# REVIEW COMMENTS

<b>Project:</b>		<i>In-N-Out (Gibson)</i>		<b>PDE:</b>		
<b>Review:</b>		<i>Draft Dated 10/29/2024</i>		<b>Reviewers:</b>		
<b>Date:</b>		<i>2/12/2025</i>		<i>Curtis Cherne, PE for CABQ Philip Gallegos, PE (Wilson &amp; Co) for NMDOT</i>		
<b>#</b>	<b>PAGE</b>	<b>SECTION</b>	<b>COMMENT</b>	<b>AGENCY</b>	<b>STATUS</b>	<b>RESPONSE</b>
1			Trips were assigned to a driveway three, which does not exist. See HCS Two-Way Stop-Control Report pp 130 and 131, 158 and 159 of 173. Reassign trips to the two driveways shown on the Site Plan. Additional comments/questions may arise after the revised information is presented.	CABQ	Agree	No trips were assigned to DWY 3 in report body, they were assigned as stated in the report. Errant old HCS reports were found in the appendix and removed.
2			The queue and delays for Alumni Dr SBL will most likely be long. With a long SBL queue and delay, drivers may make a SBR onto Gibson Blvd then execute a U-turn at Mulberry Dr. Provide a discussion and recommendation(s), if any, to reduce the queue for the Alumni Dr SBL and to mitigate the U-turn at Gibson Blvd and Mulberry Dr.	CABQ	Agree	Added U-turn to discussion on page 40 and updated rec

CIVIL ENGINEER:
MSI ENGINEERING, INC.
 CIVIL ENGINEERS AND LAND SURVEYORS SPECIALIZING IN SITE DEVELOPMENT
 301 NORTH SAN DIMAS AVENUE, SAN DIMAS, CA. 91773
 (909) 305-2395 FAX (909) 305-2397
 Aaron D. Pellow
 AARON D. PELLOW R.C.E. 27112

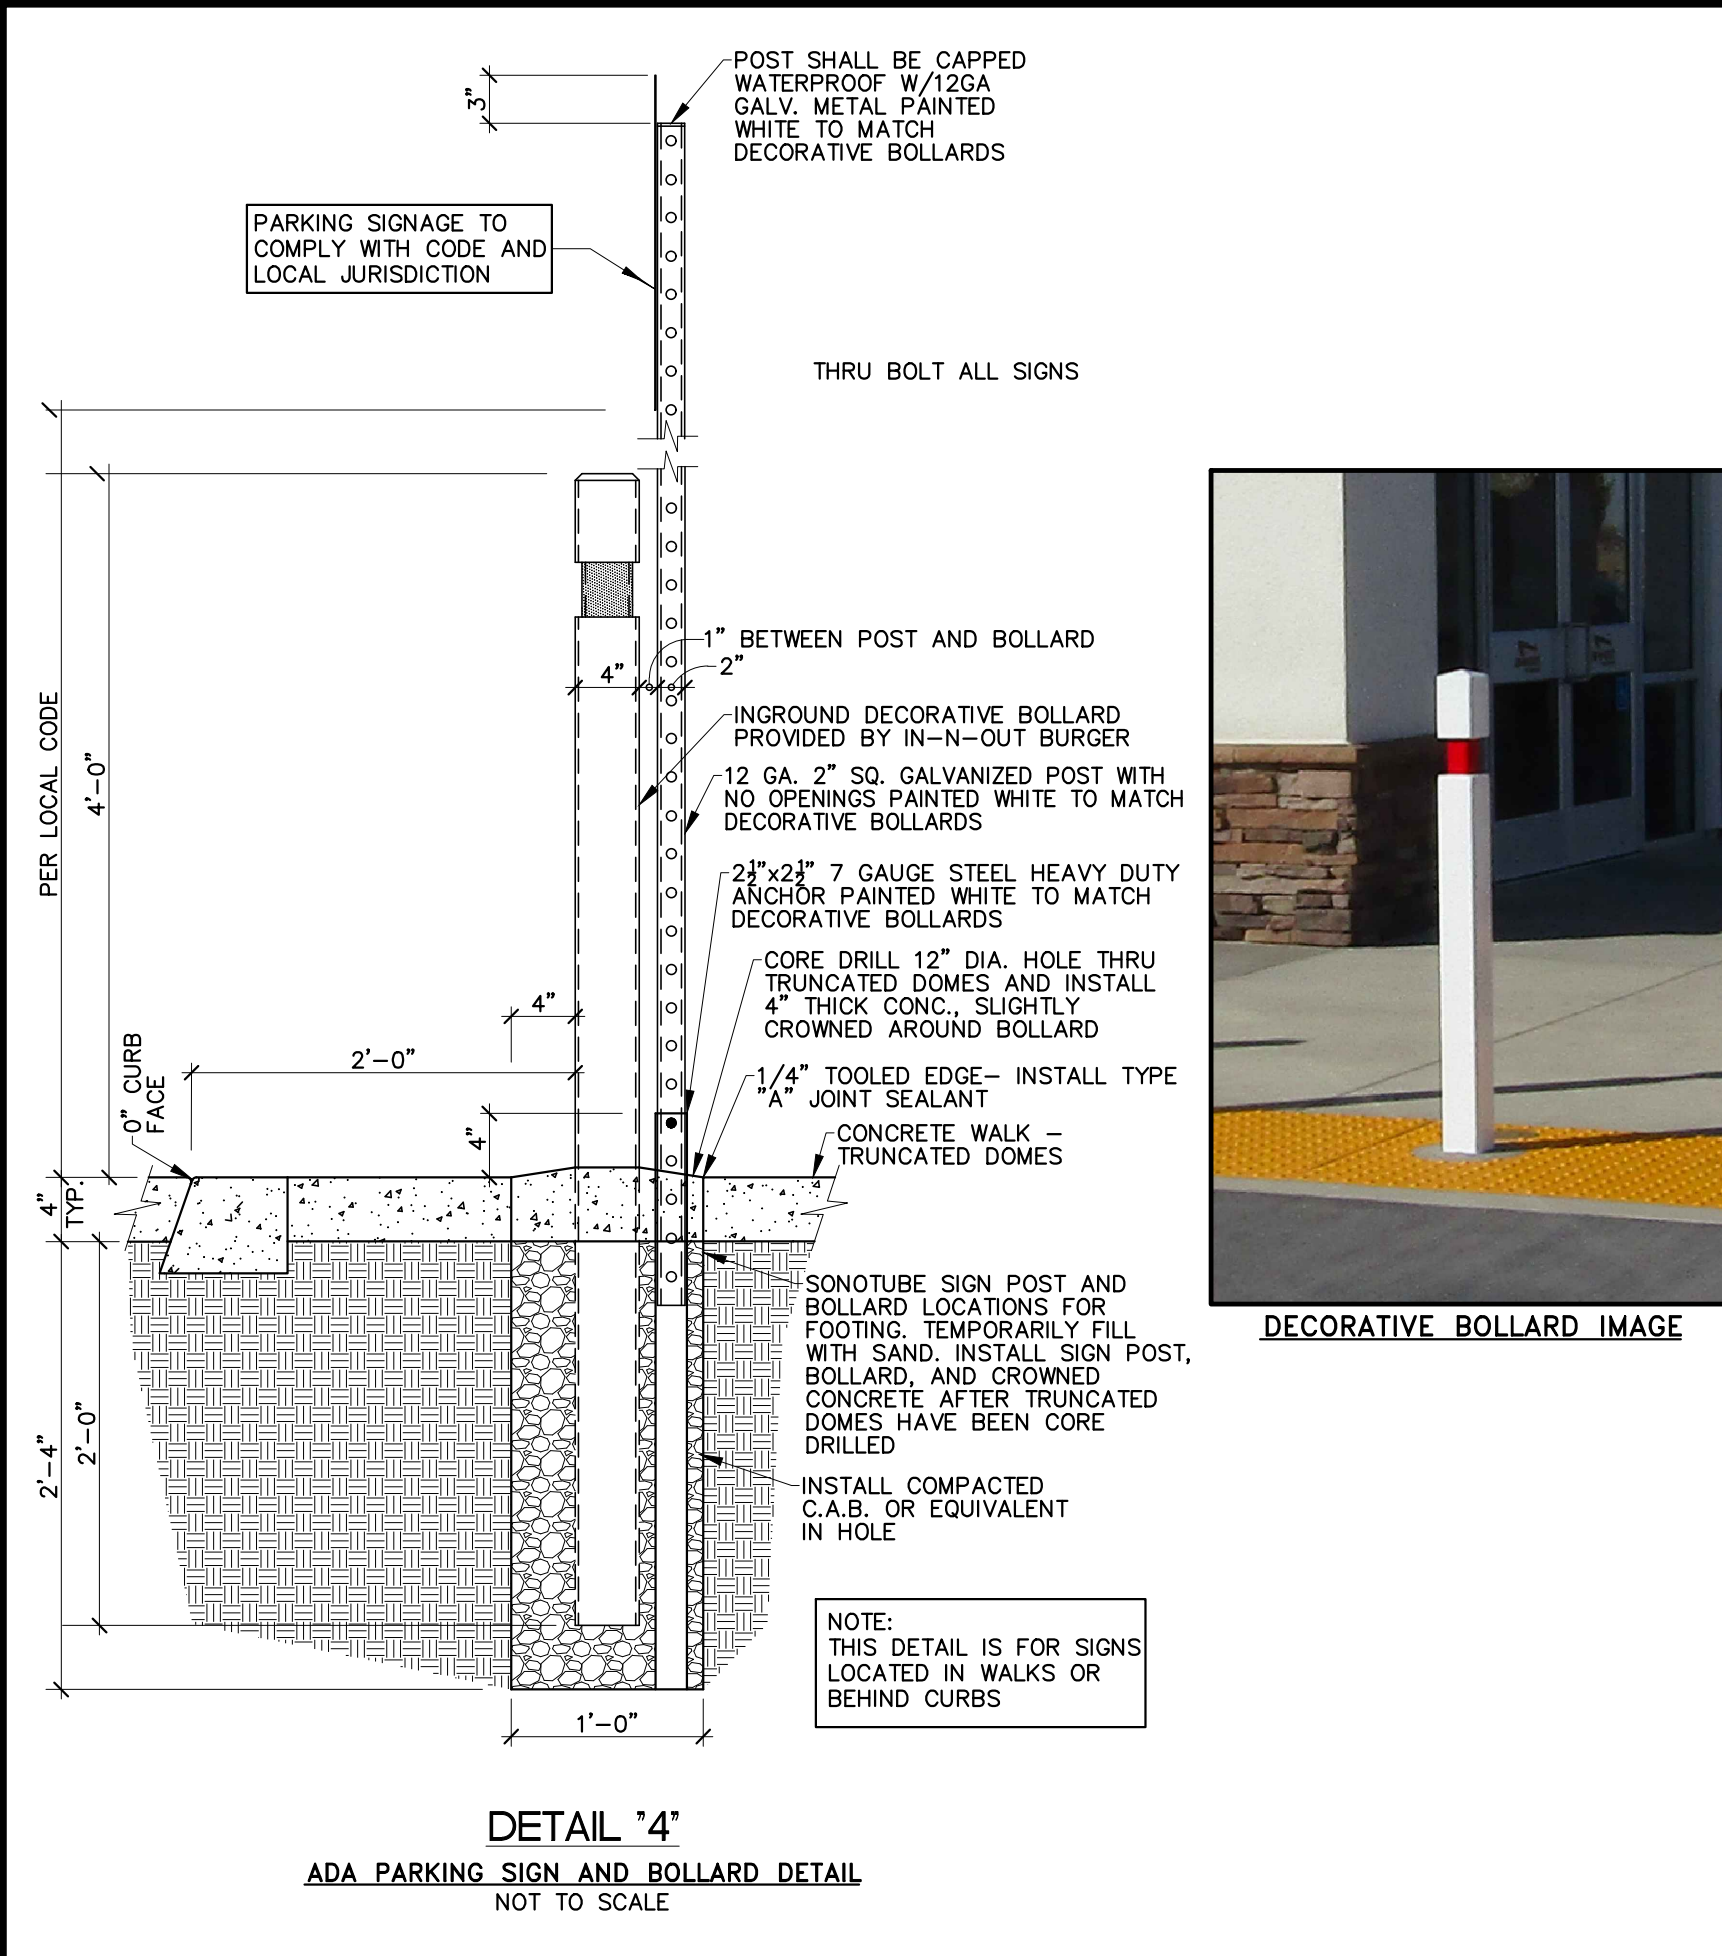
3			The Site Access and Justification paragraph mentions three access driveways, whereas, the Site Plan shows 2.	CABQ	Agree	Corrected.
4			Provide the methodology/calculations used to determine the 160 ft turn lane length: decel, storage and taper or 95% percentile queue length.	CABQ	No Action	No Action. The methodology is stated on Page 26 before Table 8.
5			Provide a clear 11” x17” site plan that shows the dimensions and striping discussed in the Auxiliary Lane Analysis section.	CABQ	Agree	In N Out has provided new stand-alone site plan.
6			Need vicinity map and legal description of the project in the introduction section as required by the NMDOT TIS Outline.	NMDOT	Agree	Vicinity Map shown in figure 2. Added legal description.
7			In the executive summary it refers to site access as being one on Gibson Blvd and 2 on Alumni Drive. Per NMDOT guidance the only access is to be on Alumni Drive which is reflected in the body of the report. Reference to site access on Gibson Blvd should be removed.	NMDOT	No Action	Report delivered on 2/14/2025 addressed this issue.

FIRE SITE PLAN

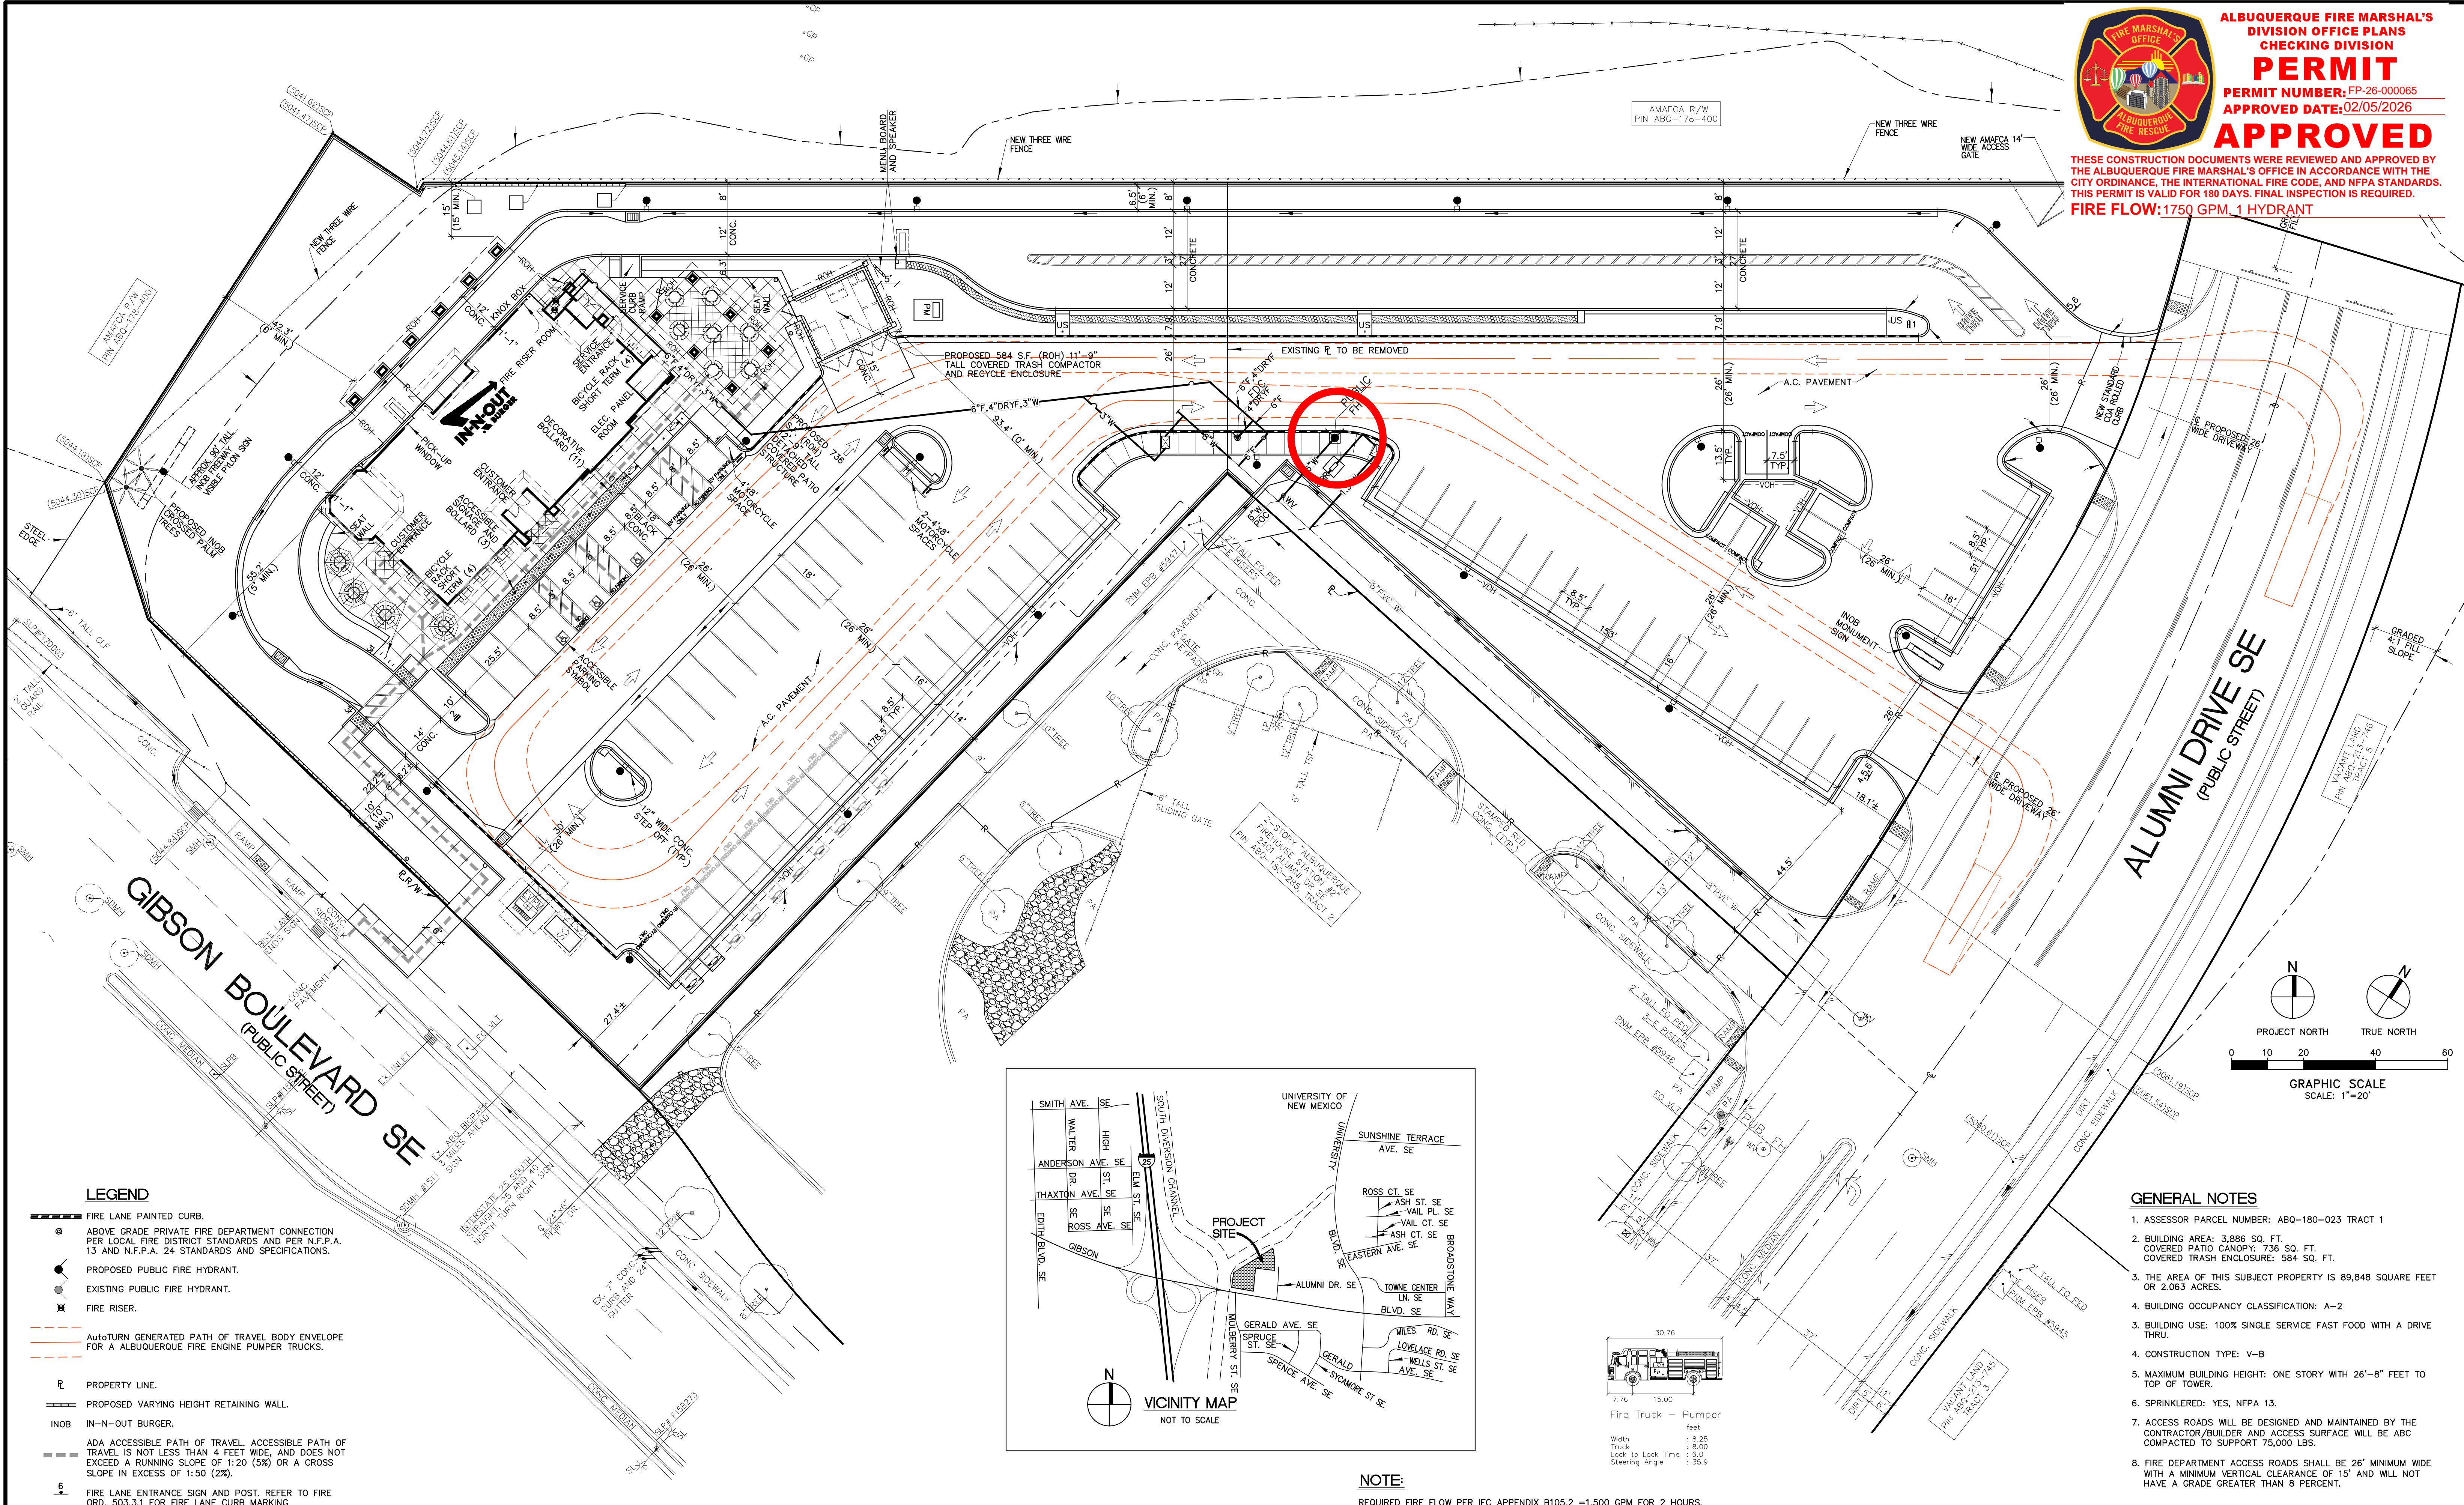
11			The report should elaborate on the fire station access analysis and how the queuing affects that access to demonstrate that the “Do Not Block Intersection” sign (R-10-7) is sufficient to address unhindered access to the fire station.	NMDOT	Disagree	R-10-7 regulatory signs are standard practice. Signs are existing.
12			Report should reference that bike and pedestrian facilities will not be impacted by the two full access driveways and associated queuing and that construction of the driveways will comply with ADA and Bike Facility requirements.	NMDOT	Agree	Language added to state driveways will not impede pedestrian facilities and that driveways should meet ADA requirements.
